CITY OF PORTLAND

Located At 27 DEDHAM ST

Job ID: 2012-07-4443-SF

From: Jonathan Rioux
To: JFGLCSW@hotmail.com; vjkavanaugh@hotmail.com
Date: 8/1/2012 2:28 PM
Subject: 27 Dedham St.

**SECOND FLOOR PLAN**  
SCALE: 1/4" = 1'-0"

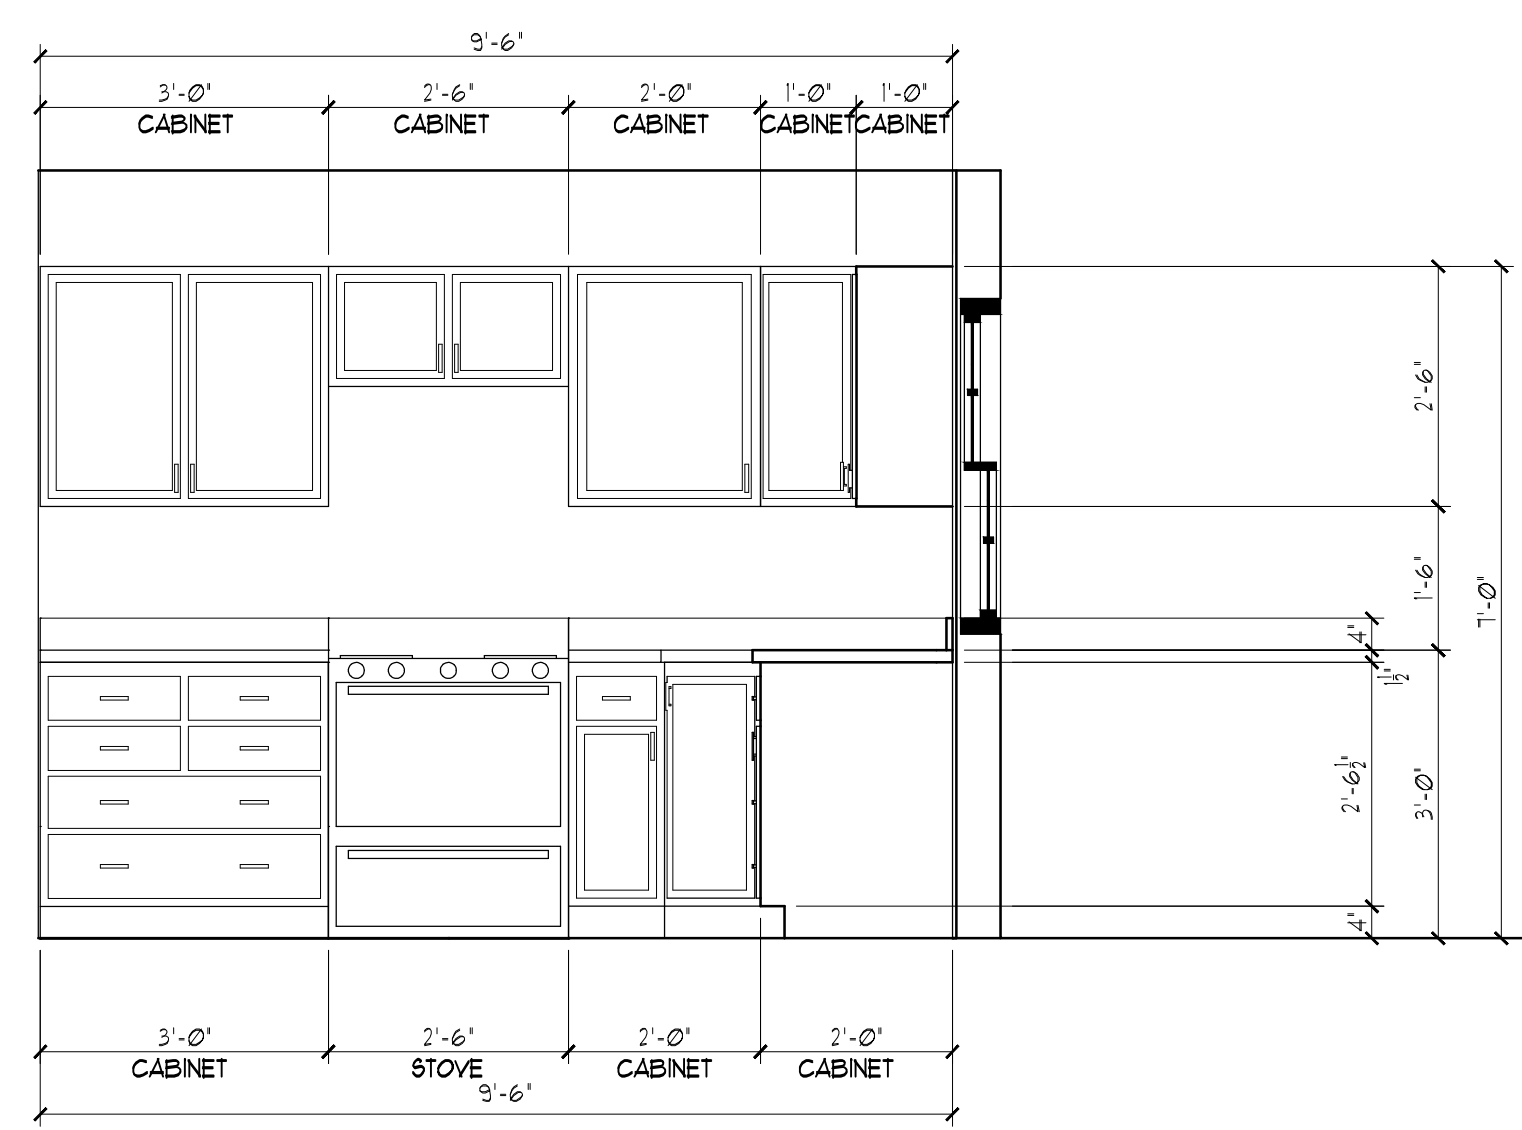
4. Sheathing; Floor & Wall (Table R503.2.1.1(1)?
5. Emergency Escape and Rescue Openings (Section R310)- Egress windows in bedrooms?
6. Window sills in locations more than 72 inches from finished grade shall be a minimum of 24 inches above the finished floor of the room, unless a window fall prevention devices is installed in accordance with section R612.3.

7. A code compliant emergency escape shall be provided in each bedroom. Window sills in locations more than 72 inches from finished grade shall be a minimum of 24 inches (no higher than 44 inches) above the finished floor of the room, or in compliance with Section R612.4.2 Operation for emergency escape.

**STAIR SECTION**  
 SCALE: 1/2" = 1'-0"

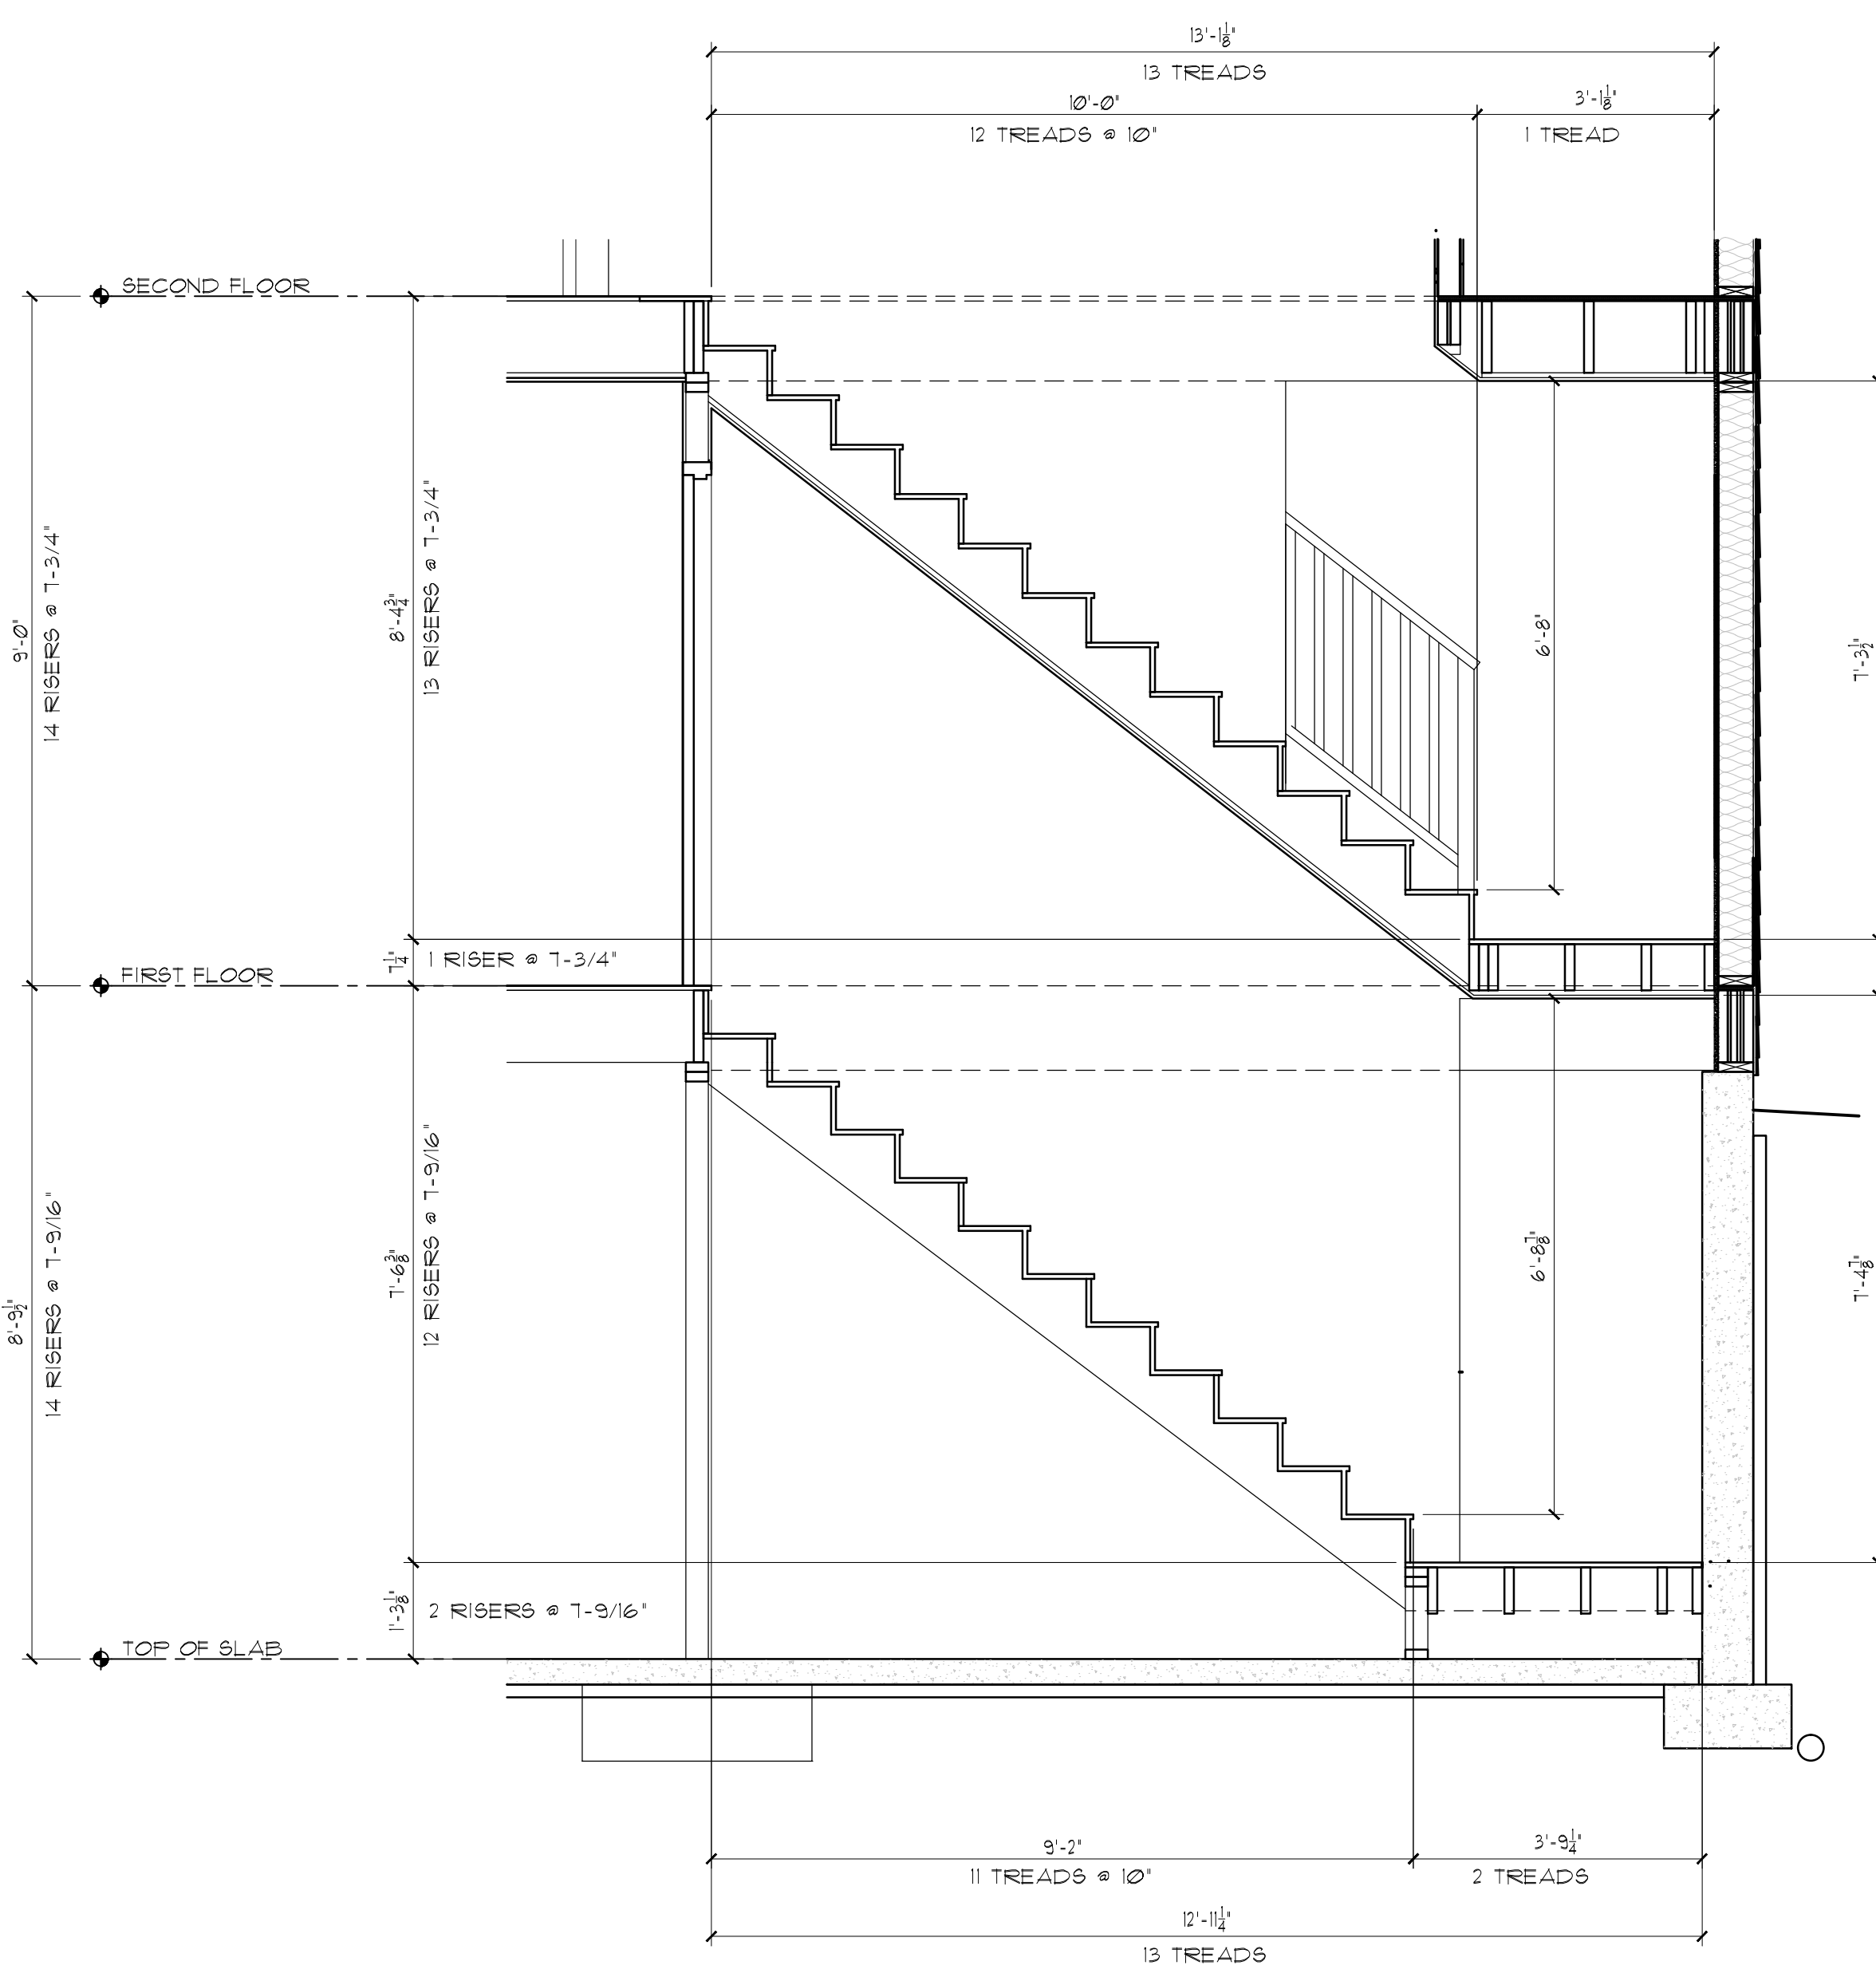
12. Stairway headroom shall be not less than 6 feet 8 inches measured vertically from the sloped plane adjoining the tread nosing or from the floor surface of the landing or platform?
